CITY OF ALBUQUERQUE

September 23, 2016

Re: Construction Seminars
4927 Prospect Ave NE; Bldg Permit # 201691091
30-Day Temporary Certificate of Occupancy- Transportation Development
Architect's Stamp dated 08-04-16 (H17D112)
Certification dated 09-21-16

AS-120

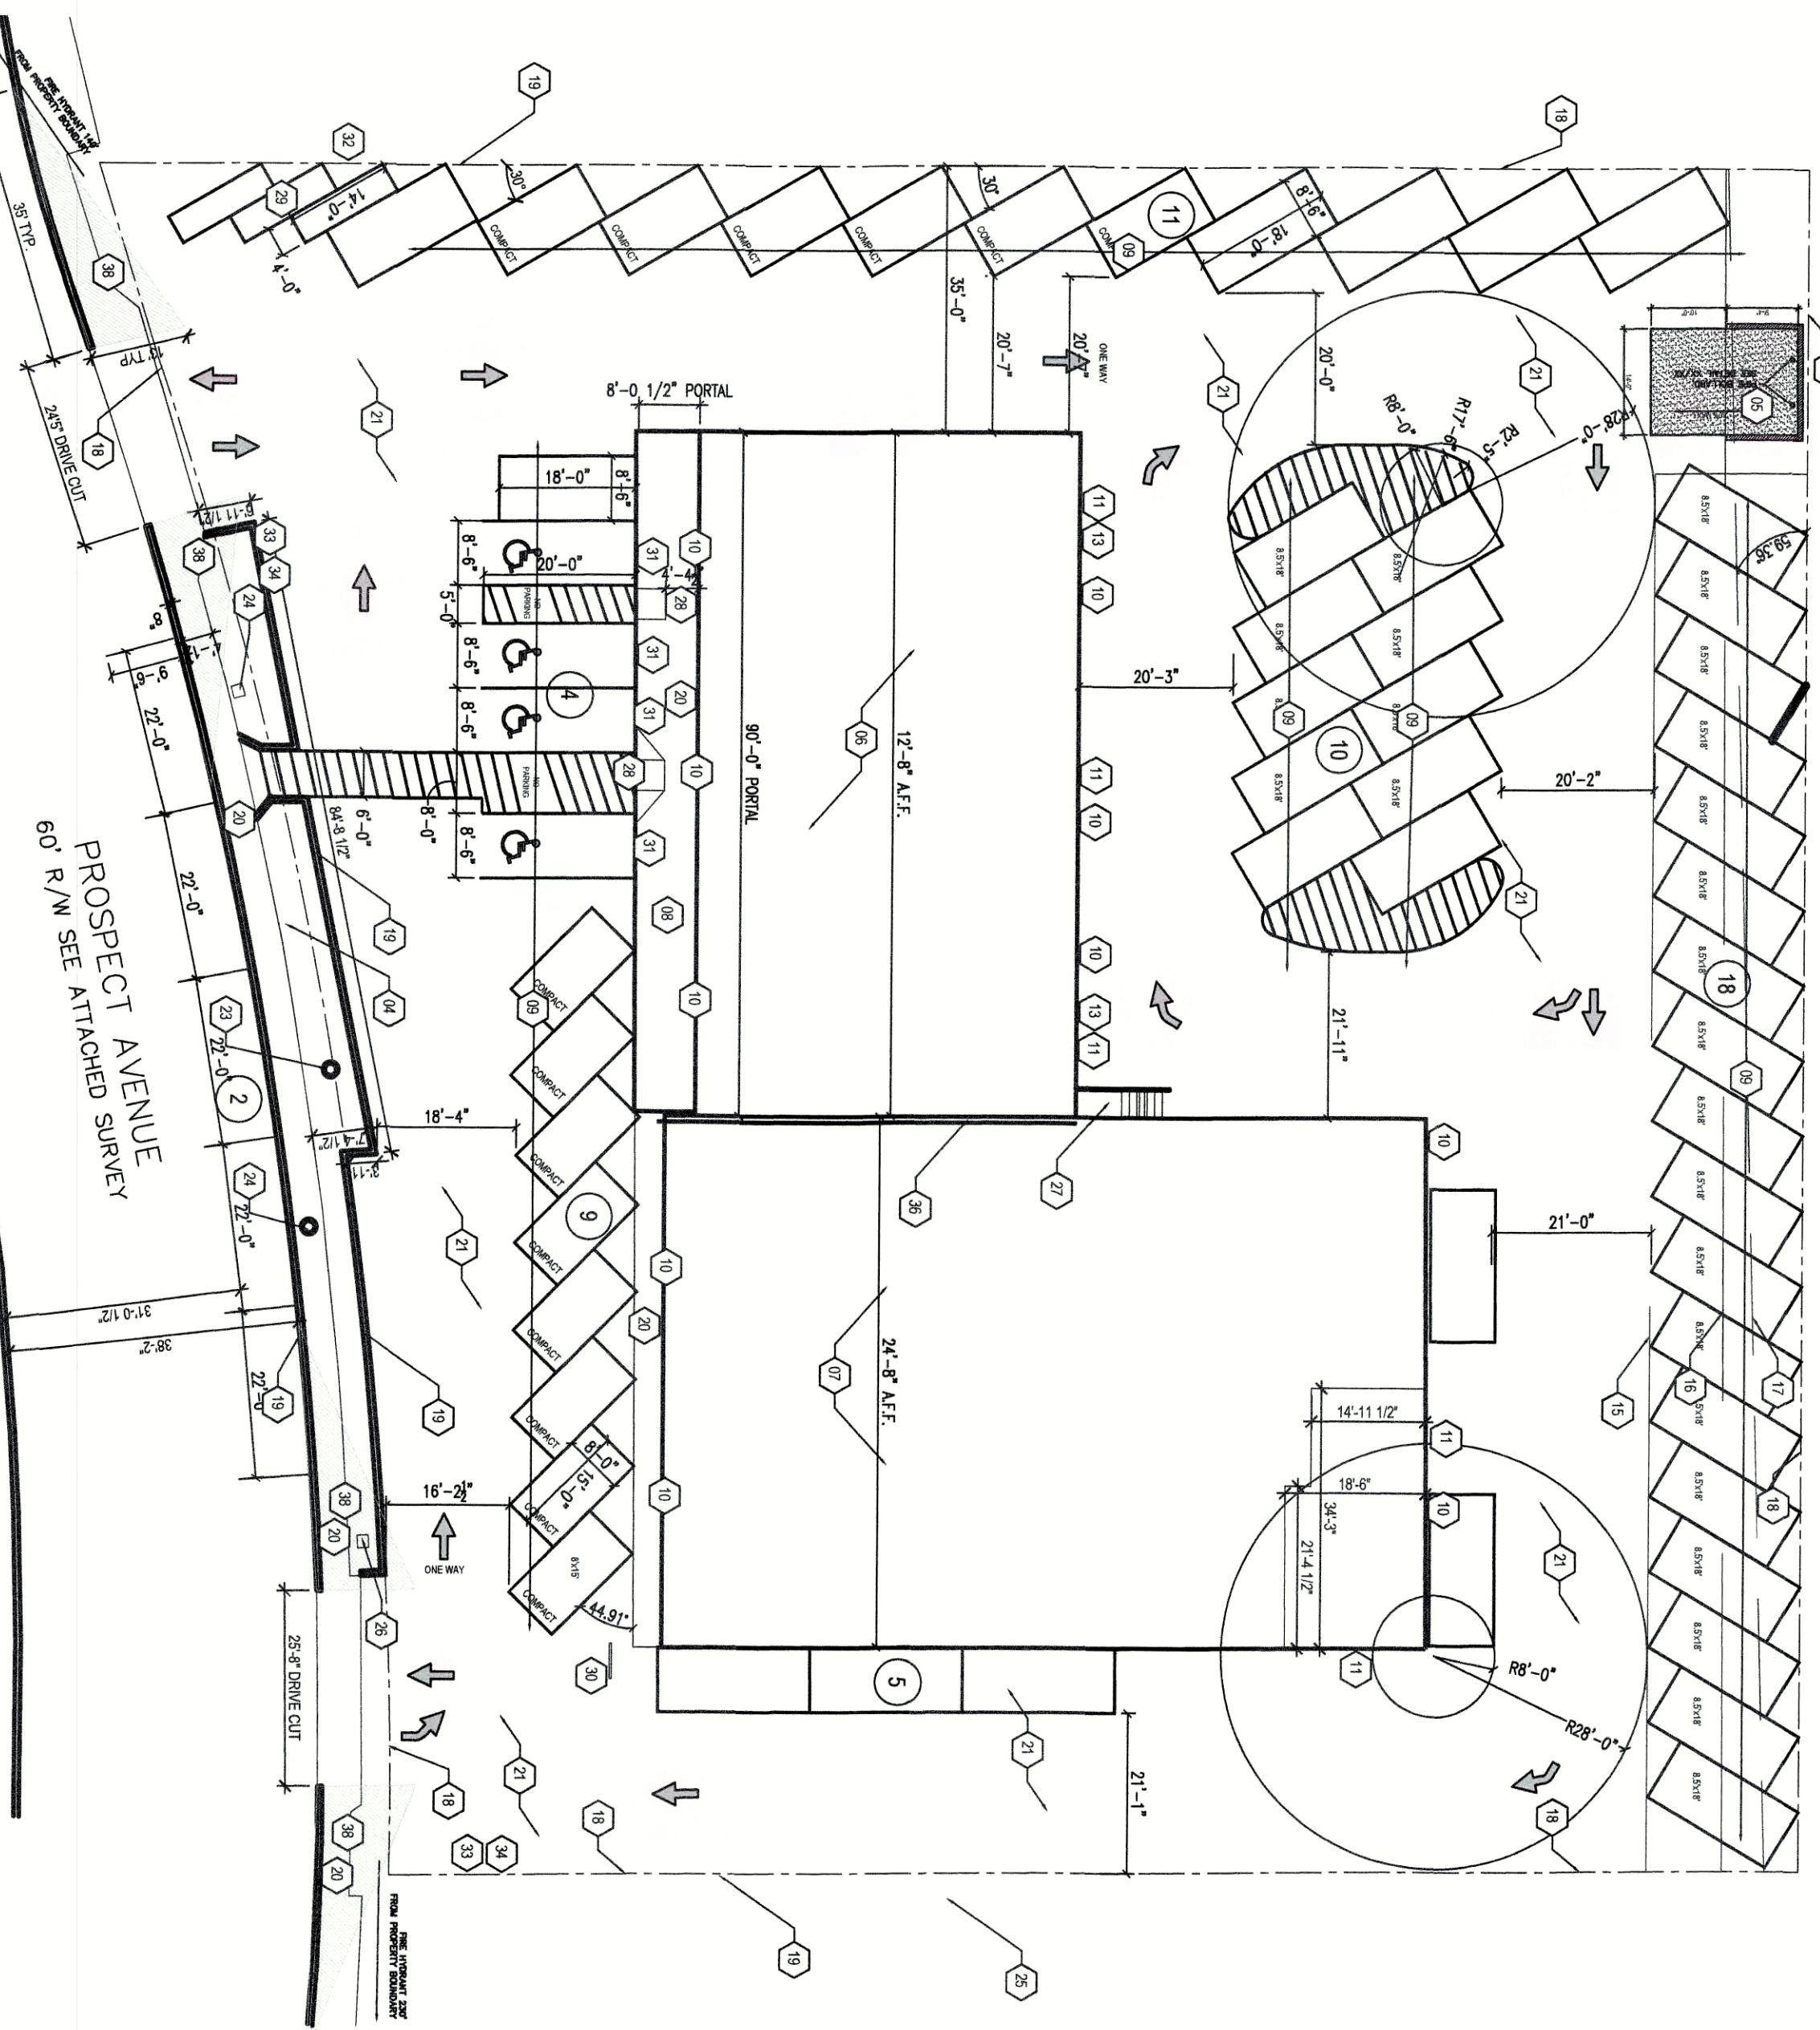
1. The 6' pedestrian access aisle called out on the approved TCL must be completed per plan.
2. The ADA access aisle route to the warehouse is not in compliance with ADA guidelines for slopes requirements. One HC parking space and access aisle will need to be relocated to allow proper ADA access to the building.
